## **Stratton Audley Parish Council**

### **Response to Planning Application - Padbury Brook Solar Farm by Messrs JBM**

#### **Opposing the Development February 2023**

TITLE:
PV table details

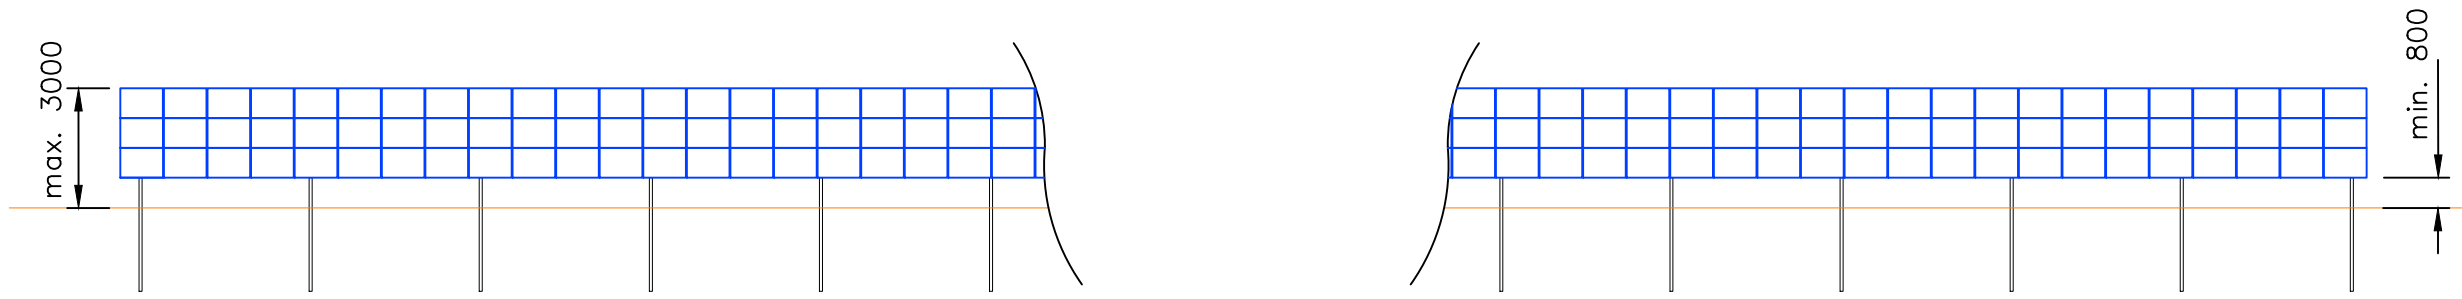
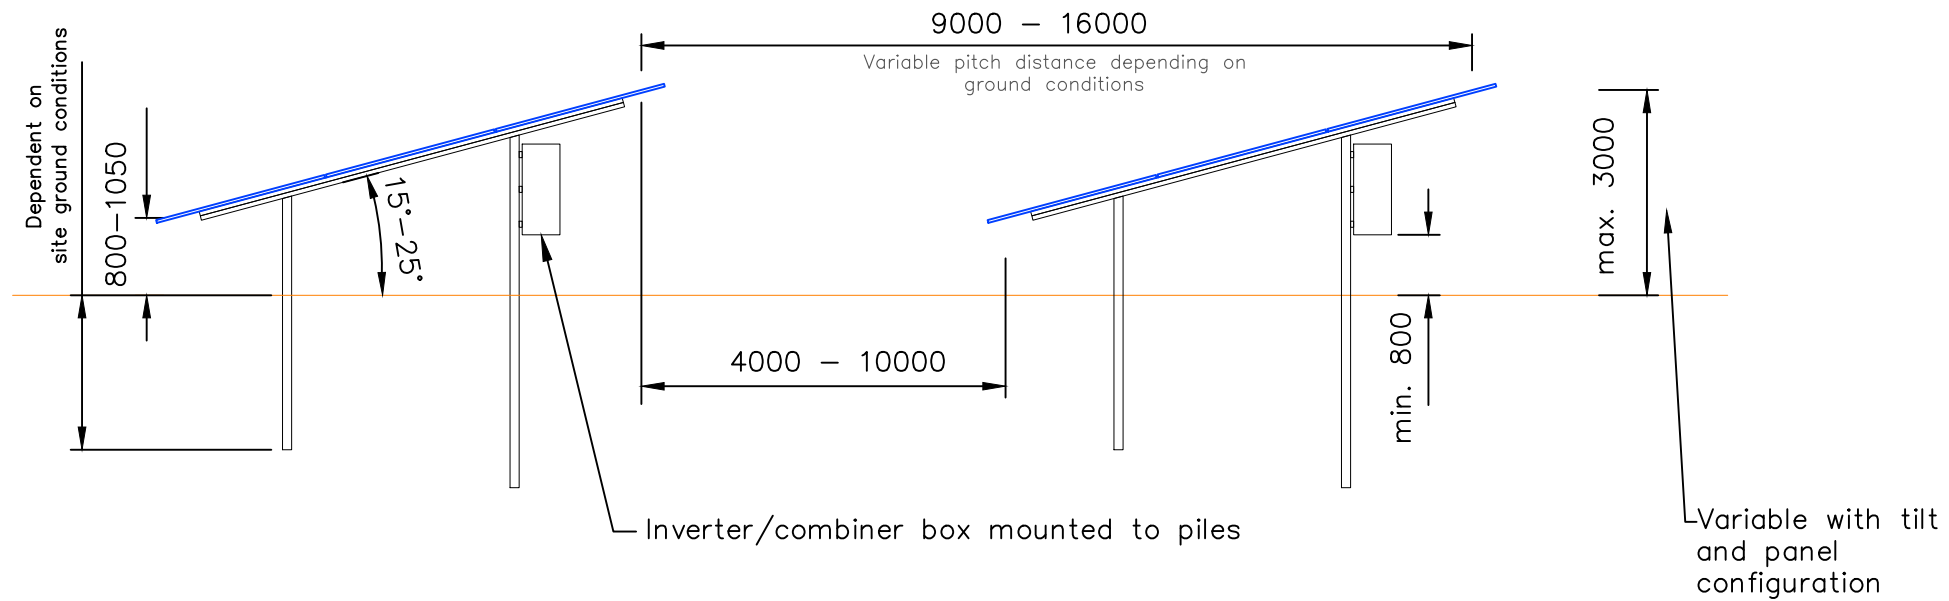
It should also be noted that according to JBM, the solar panels extend up to 9ft to their top edge, a height which exceeds that of most of the existing hedgerows. This is far from low-profile, presumably necessitated because this is essentially a North-facing sloped site, and hence solar gain is lower.

- 5) Further information supported by technical evidence to indicate why the solar panels to be installed on the site cannot be lowered in height.
